April 7, 2020

**SUBJECT: Bent Grass Meadows Drive & Meridian Road  
Construction Drawing Review (CDR) – Letter of Intent**

This Letter of Intent (LOI) is being submitted as part of the Construction Drawing Review (CDR) Application. Challenger Communities, LLC is proposing to construct a right turn lane from Bent Grass Meadows Drive onto Meridian Road, and also a south bound 960' long acceleration lane and 222' taper along Meridian Road.

MERIDIAN ROAD DRAINAGE
PLAN

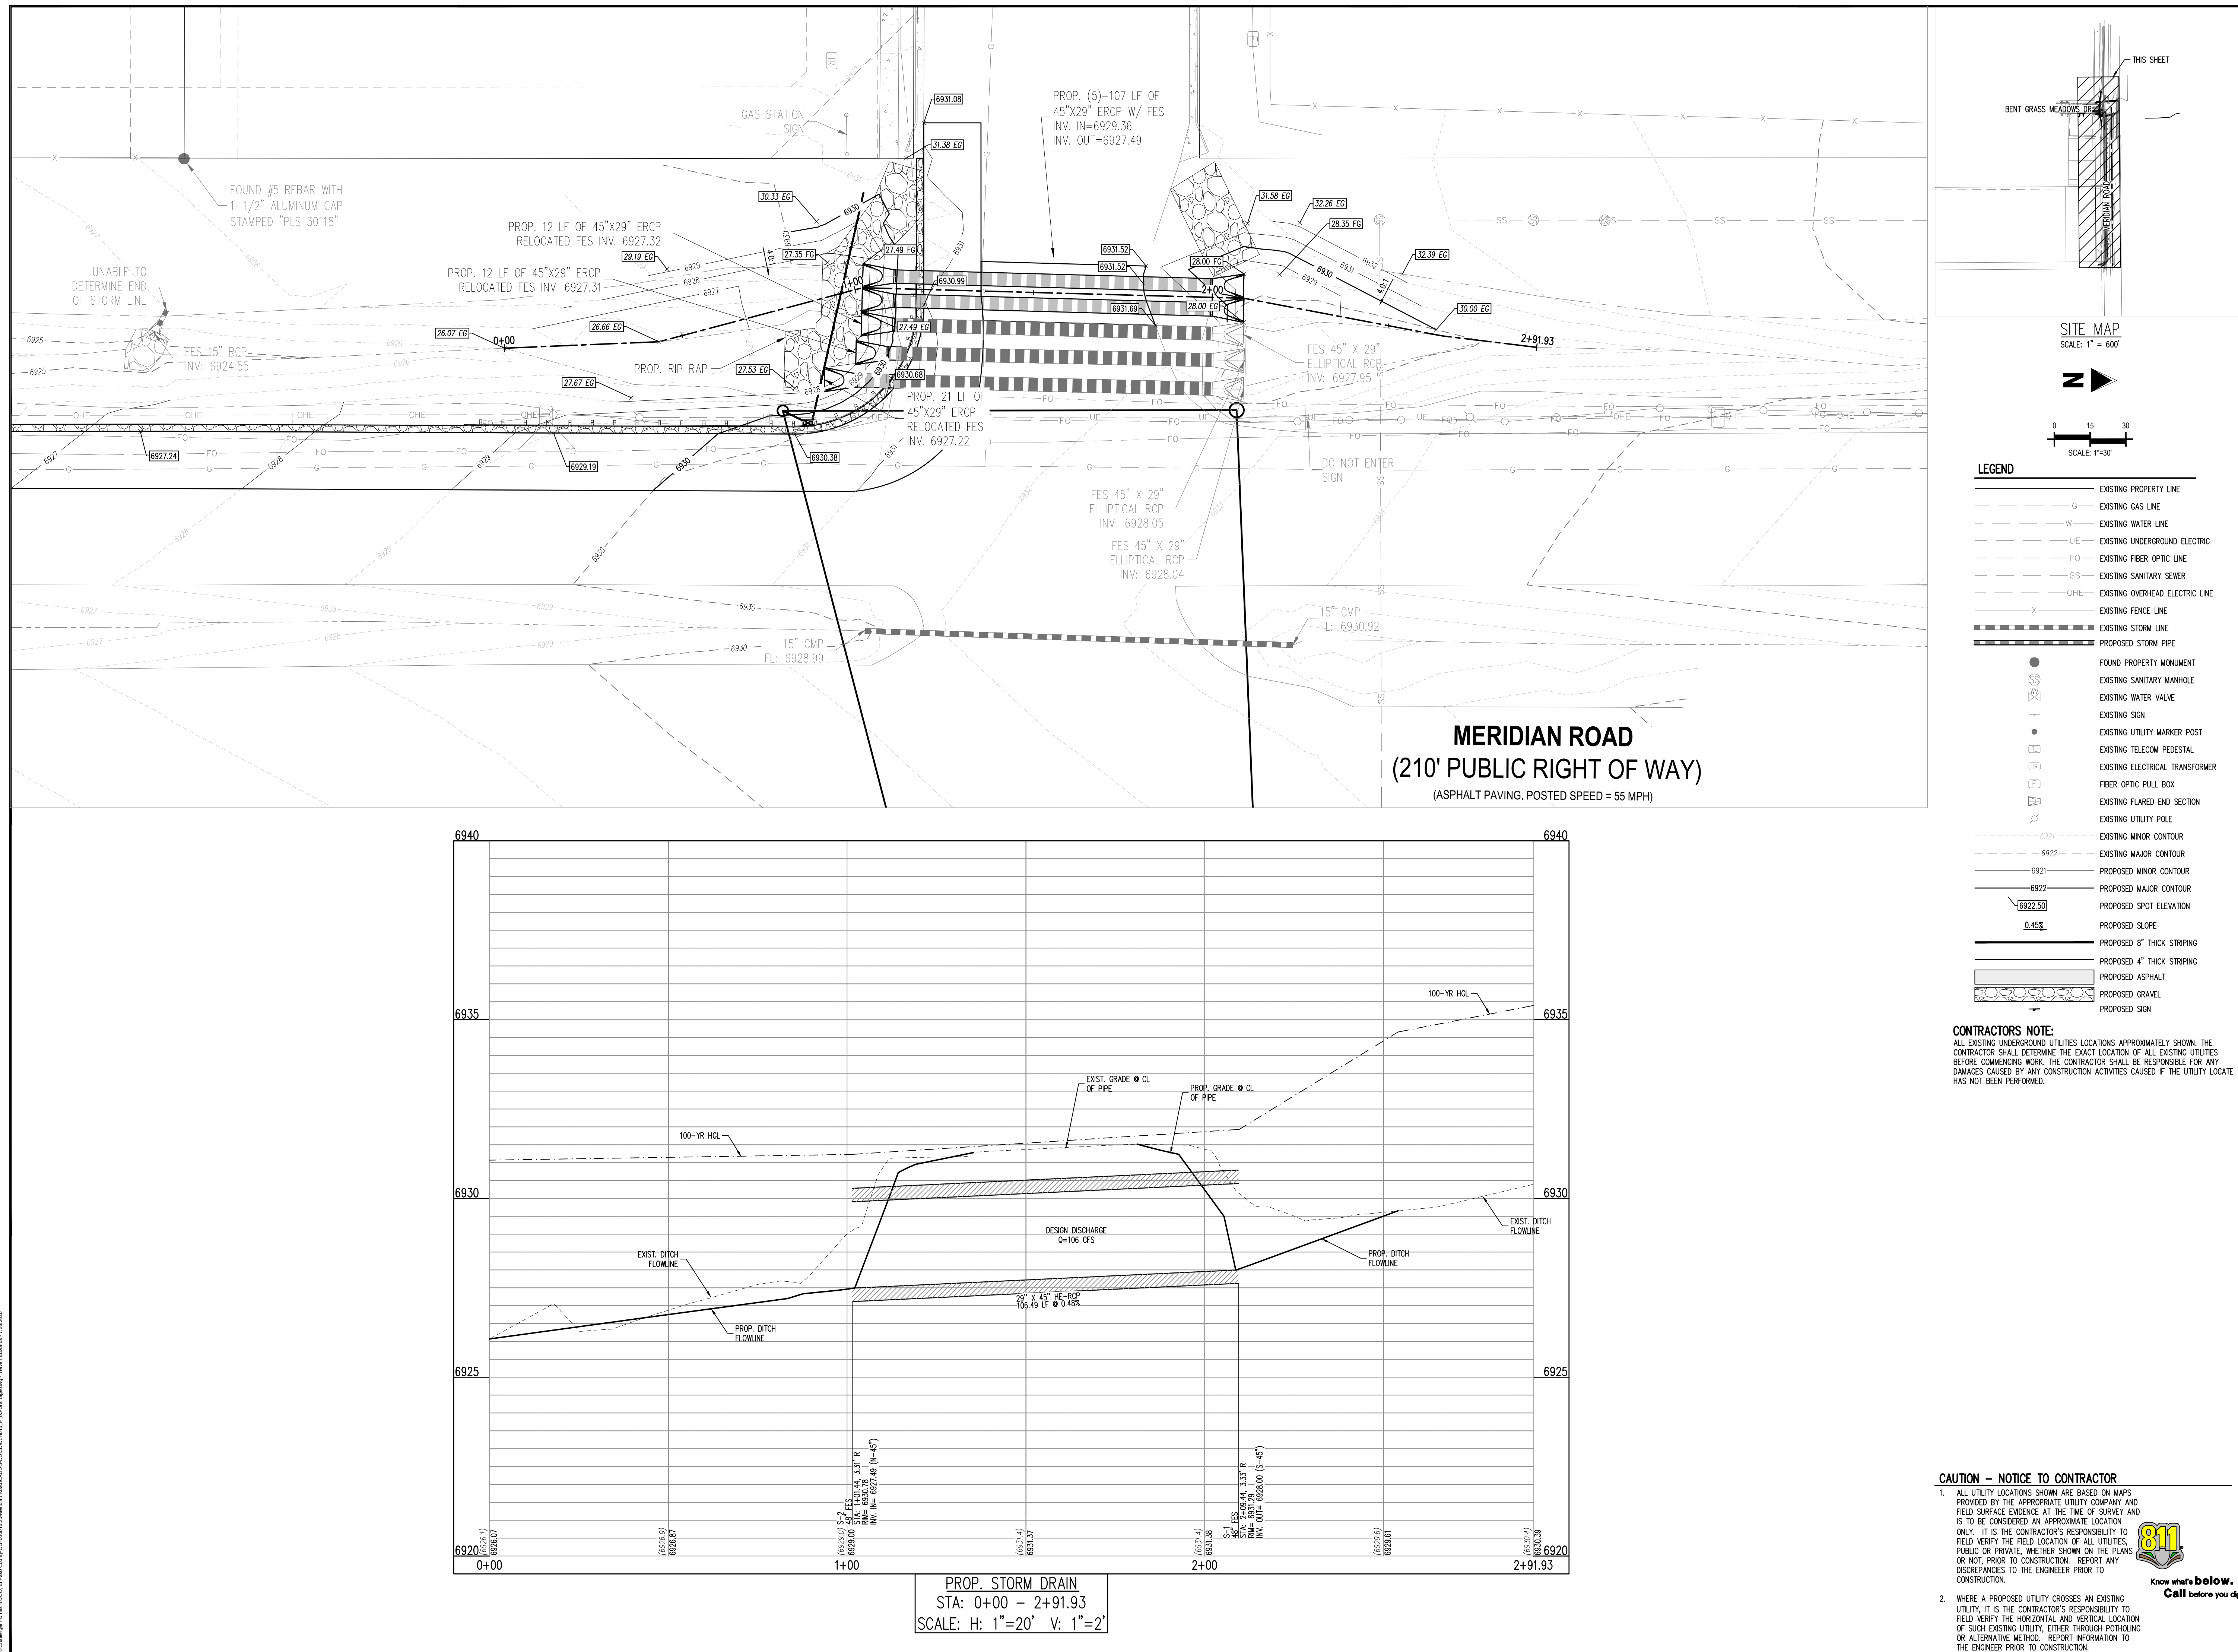
verify

SIZE OF ELLIPTICAL PIPE VERIFIED AND ADDRESSED IN THE DRAINAGE LETTER.
